Application Ref:	3/2025/0530			 Ribble Valley Borough Council www.ribblevalley.gov.uk	
Date Inspected:	31/07/2025	Site Notice:	N/A		
Officer:	MC				
DELEGATED ITEM FILE REPORT:					REFUSAL

Development Description:	Proposed erection of a timber-framed agricultural building with stable.
Site Address/Location:	Coxes Farm Stoneygate Lane Ribchester PR3 2ZS

Block Plan-0.S Map

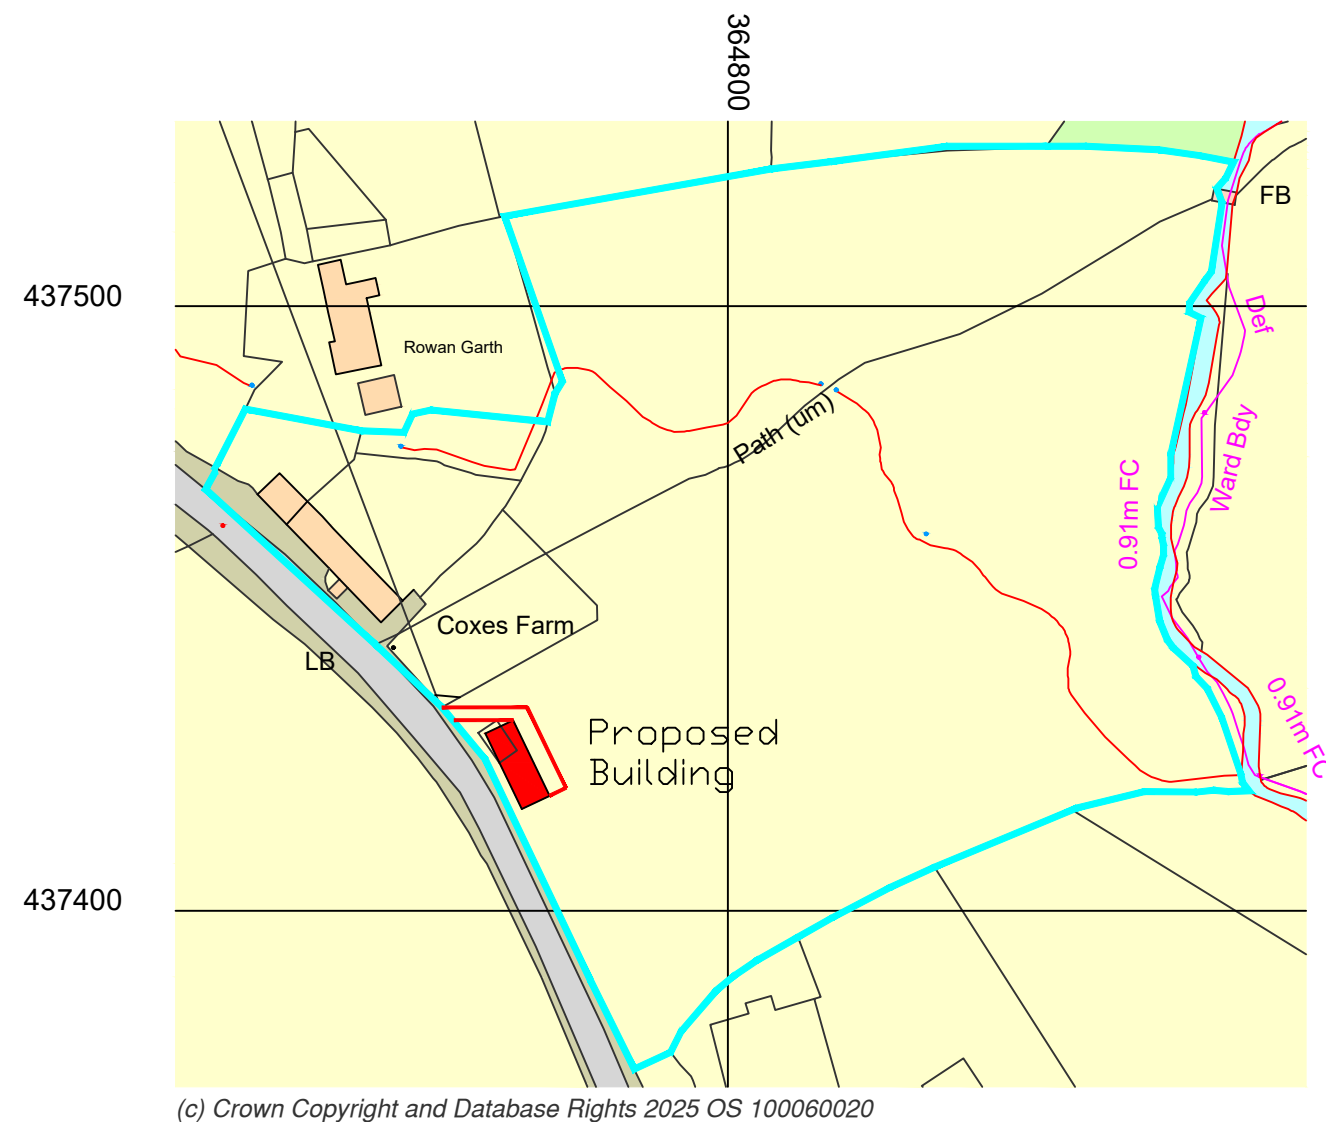
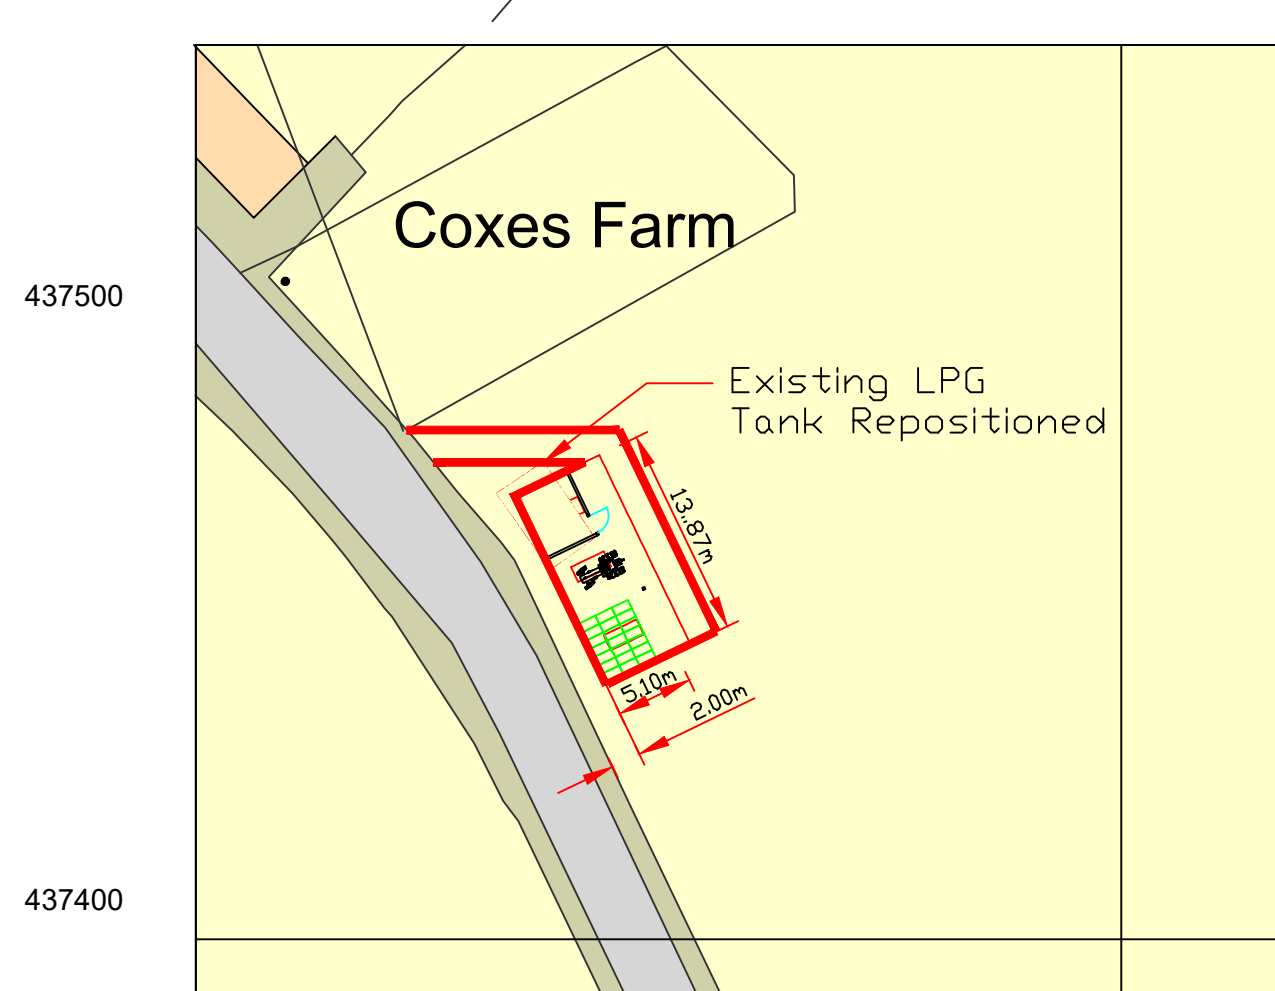
With regards to the acceptability of the design/layout of the building, the Council raise concerns regarding the size and siting of the structure within the Open Countryside. Whilst the building has been sited adjacent to the existing hedgerow, the building would only be sited approximately 2 metres from the boundary with the highway. With an eaves height of 3.2 metres and a total height of approximately 3.8 metres and a length of over 18 metres, the building is considered to be prominently sited within the street scene and would result in a harmful incursion into the Open Countryside. The building would be prominently situated, being visible from the public highway and also from Public Rights of Way FP0335008 and the Council consider that there are

alternative locations within the wider site which would be more appropriate and would result in a lesser visual incursion into the Open Countryside.

As such, it is considered that the size and siting of the proposed building would result in a harmful incursion into the Open Countryside and a prominent addition of built form within the rural landscape, contrary to Policies DMG1 and DMG2 of the Ribble Valley Core Strategy.

The proposal due to its size and siting would result in a harmful incursion into the Open Countryside and a prominent addition of built form within the rural landscape, contrary to Policies DMG1 and DMG2 of the Ribble Valley Core Strategy.
